KITTITAS COUNTY

MEMORANDUM

TO: All Staff
FROM: Public Works Plan Review Team
DATE: September 28th, 2023
SUBJECT: BL-23-00021 Hutchinson

PART OF SECTIONS 2 & 11, TOWNSHIP 18 NORTH, RANGE 17 EAST, W.M.

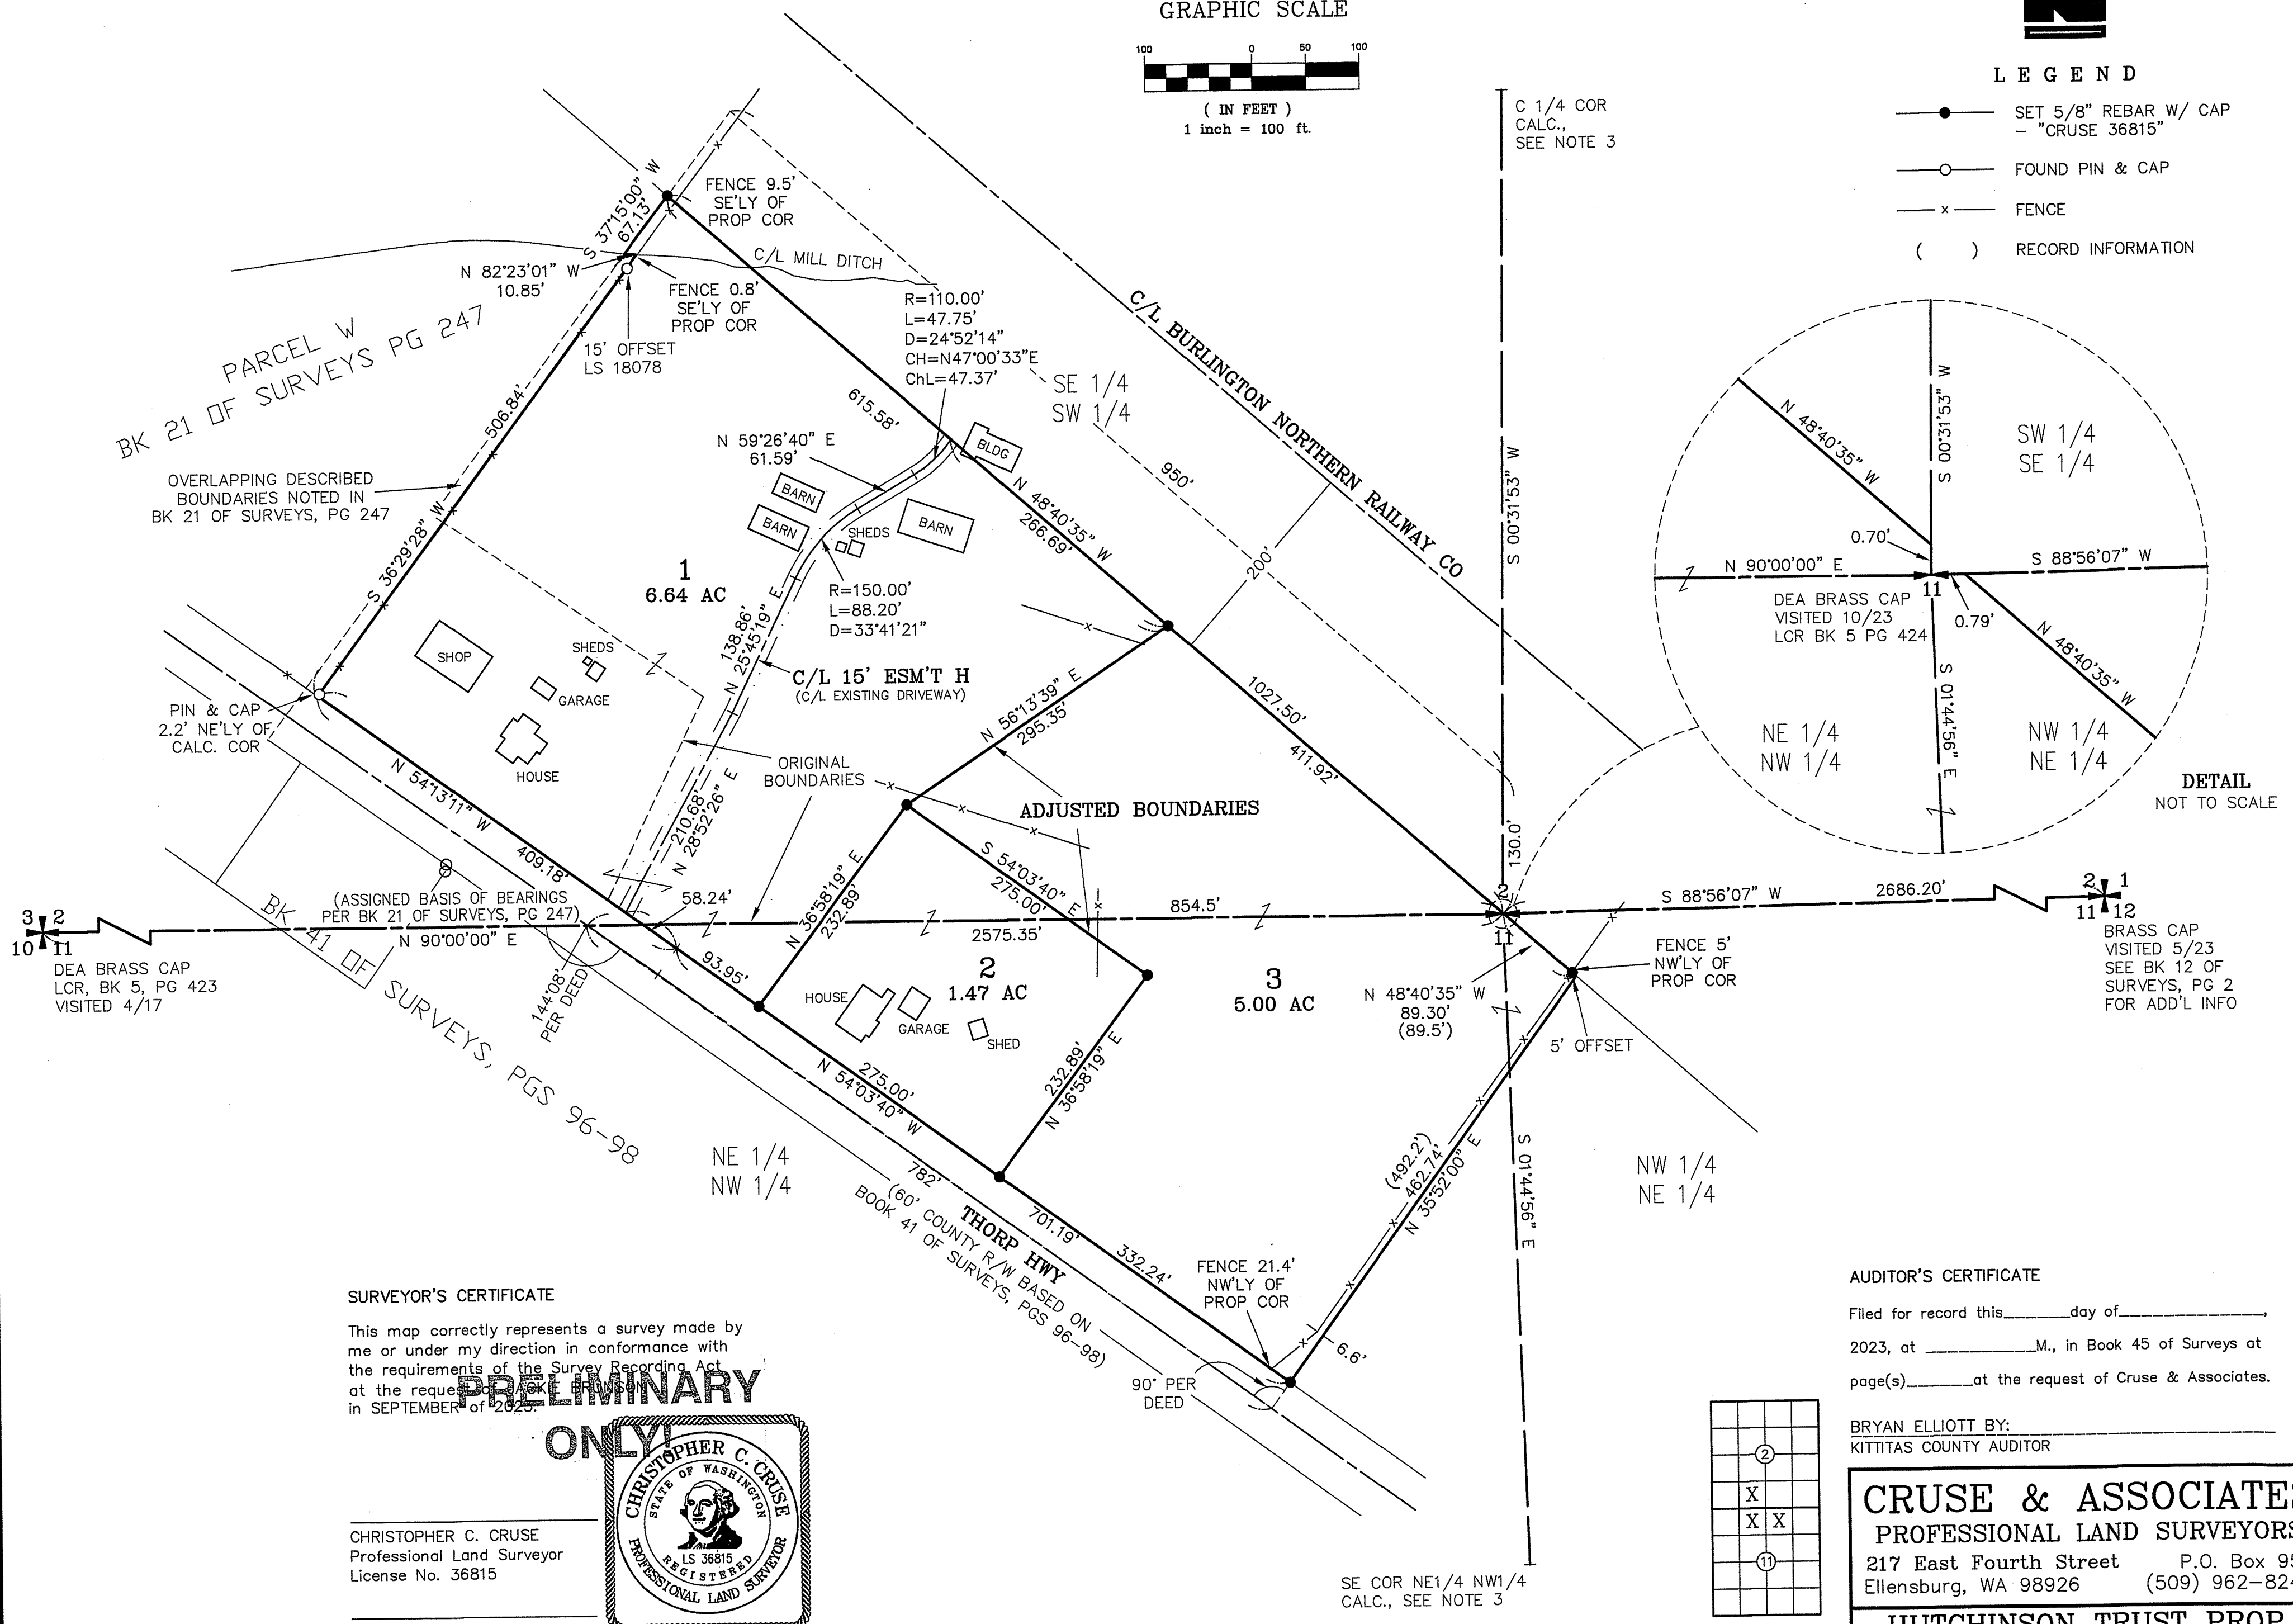
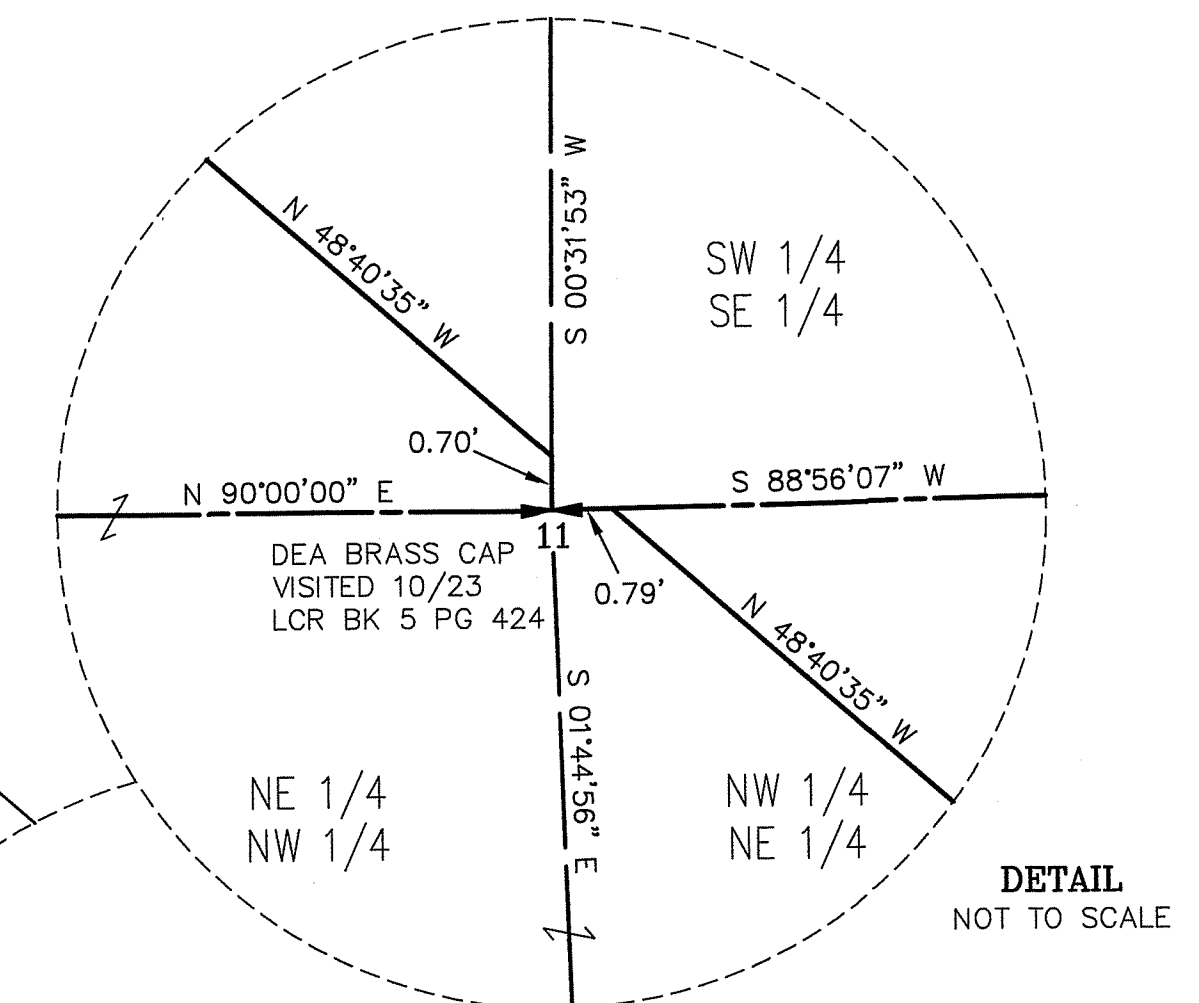
SURVEY	<p>As the application does not contain a survey map, survey reviewed is reserved until final submittal. (JT)</p> <p>UPDATE 11/17/2023</p> <ol style="list-style-type: none"> 1. Please put the deflection angles per deed in brackets to show they are record data, and that observed values may differ. This is in regards to the "144°08' PER DEED" and "90° PER DEED" notes located at the centerline of Thorp Highway. <p>UPDATE 11/29/2023 All prior survey comments have been addressed. (JT)</p>
TRANSPORTATION CONCURRENCY	<p>No Comments</p>
